**Submission to Planning Inspectorate, National Infrastructure Planning:
Ref. TR010025 25 July 2019**

Prepared by Dr. G.M. Reeves for the **Stonehenge Alliance Ref No. 2001870**

**Response to Planning Inspectorate: Examining Authority's second Written
Questions arising from the draft Development Consent Order;
Highways England proposed A303 Scheme.**

PROPOSED BORED TUNNEL - (WORK No. 1F)

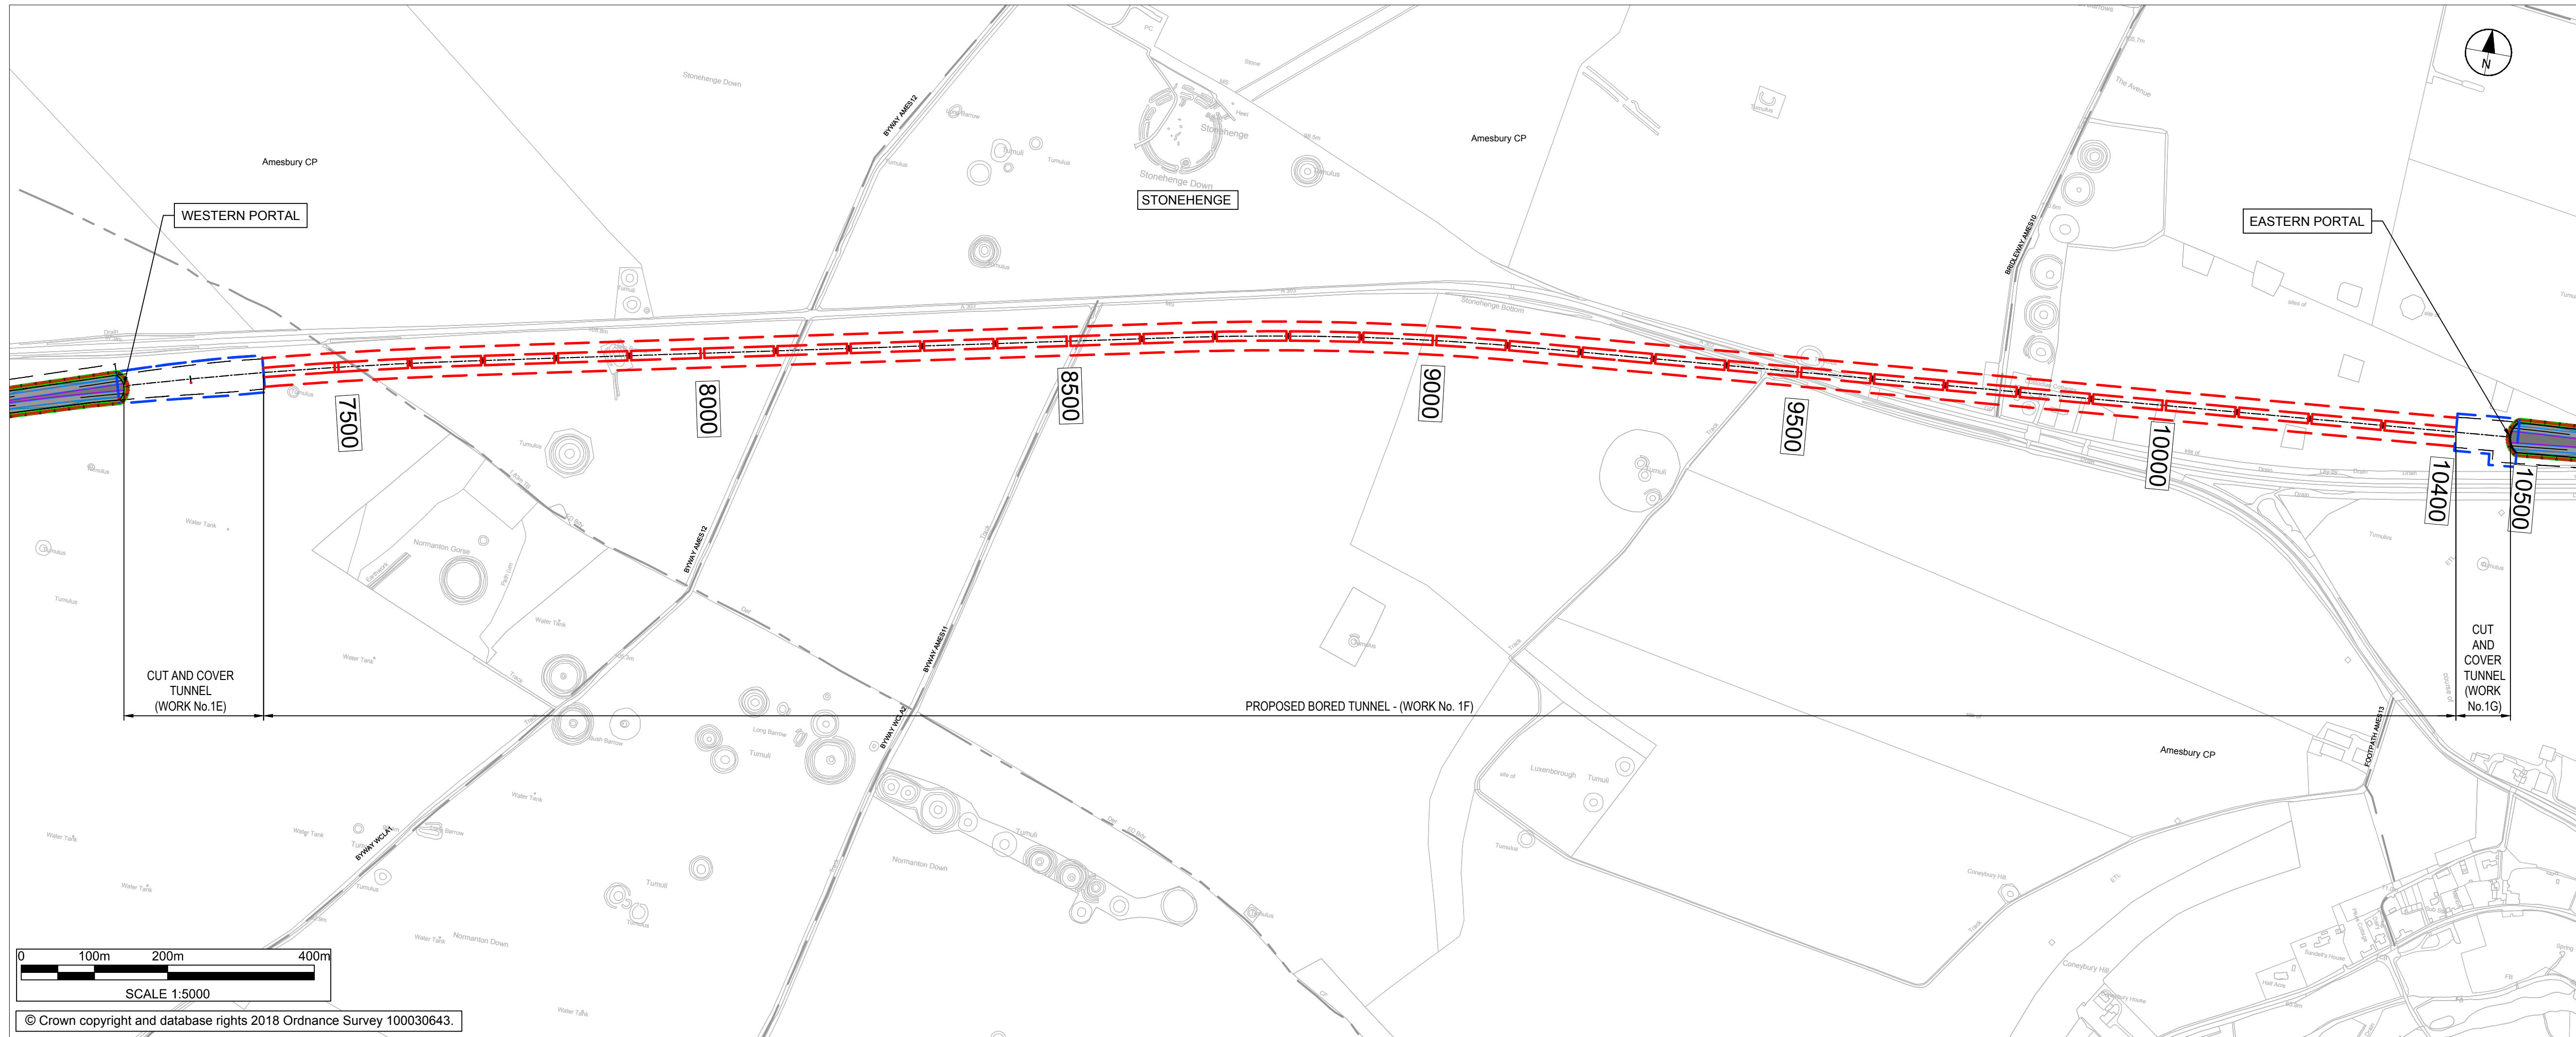
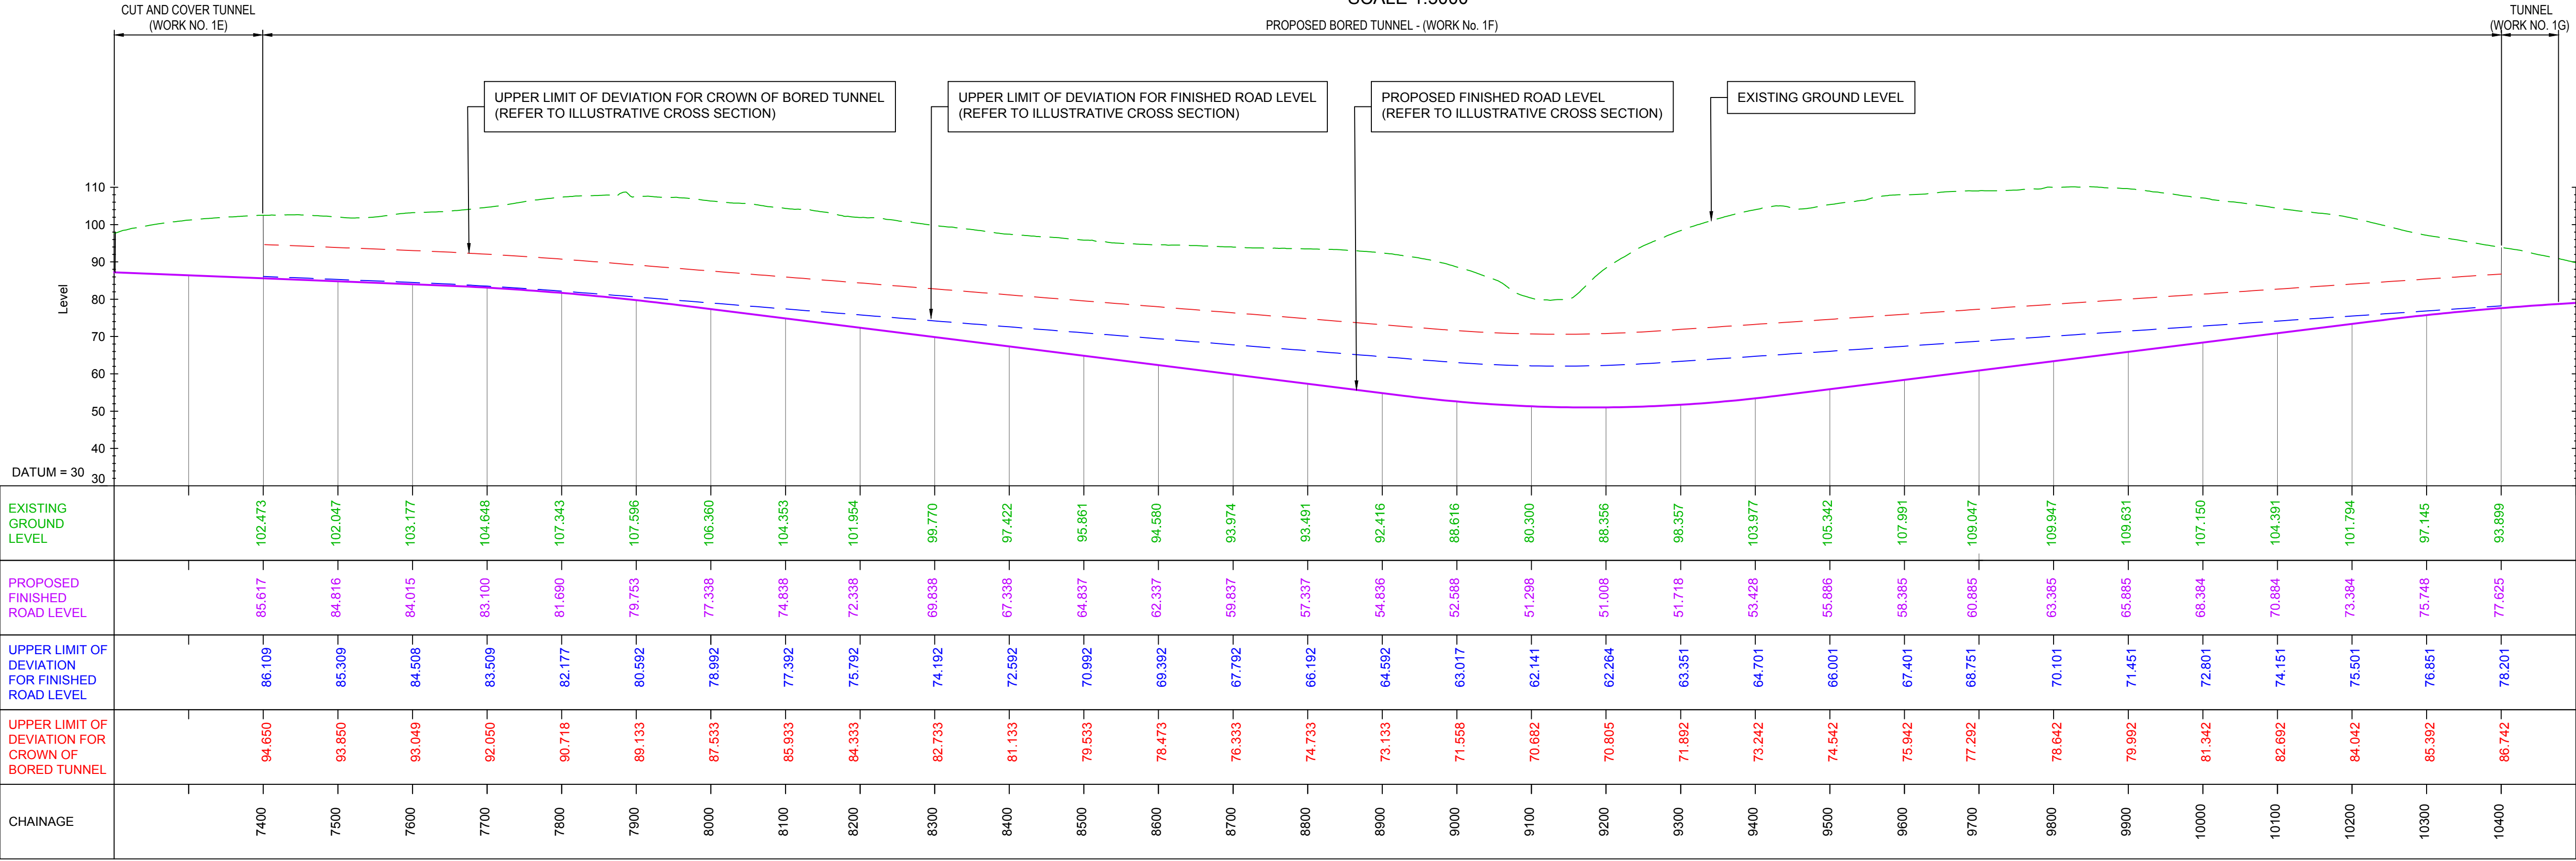
If the crown of the tunnel is located below the Stockbridge Rock, i.e. at approx. 50m BGL (55mAOD), with the road level in the tunnel at 36.3m AOD, the tunnel would be approximately 15m deeper than is currently shown in Highways England drawings. The current levels shown in the drawings (HEng. DCO Application: Documents 2.7- Engineering Section Drawings; No.7 of 24) show the crown level of the tunnel below Stonehenge Bottom at 70m AOD, and the road level at 51.3mAOD.

Therefore, if tunnelling goes deeper than proposed to the west and east of Stonehenge Bottom, the Stockbridge/Whitway Rock high permeability zone is likely to be intercepted, but not in the major fracture zone below Stonehenge Bottom.

The consequence of any such variations to the published Limits of Deviation has not been investigated, neither by site investigation drilling nor groundwater monitoring and testing, and consequently has not been part of any detailed and relevant groundwater modelling.
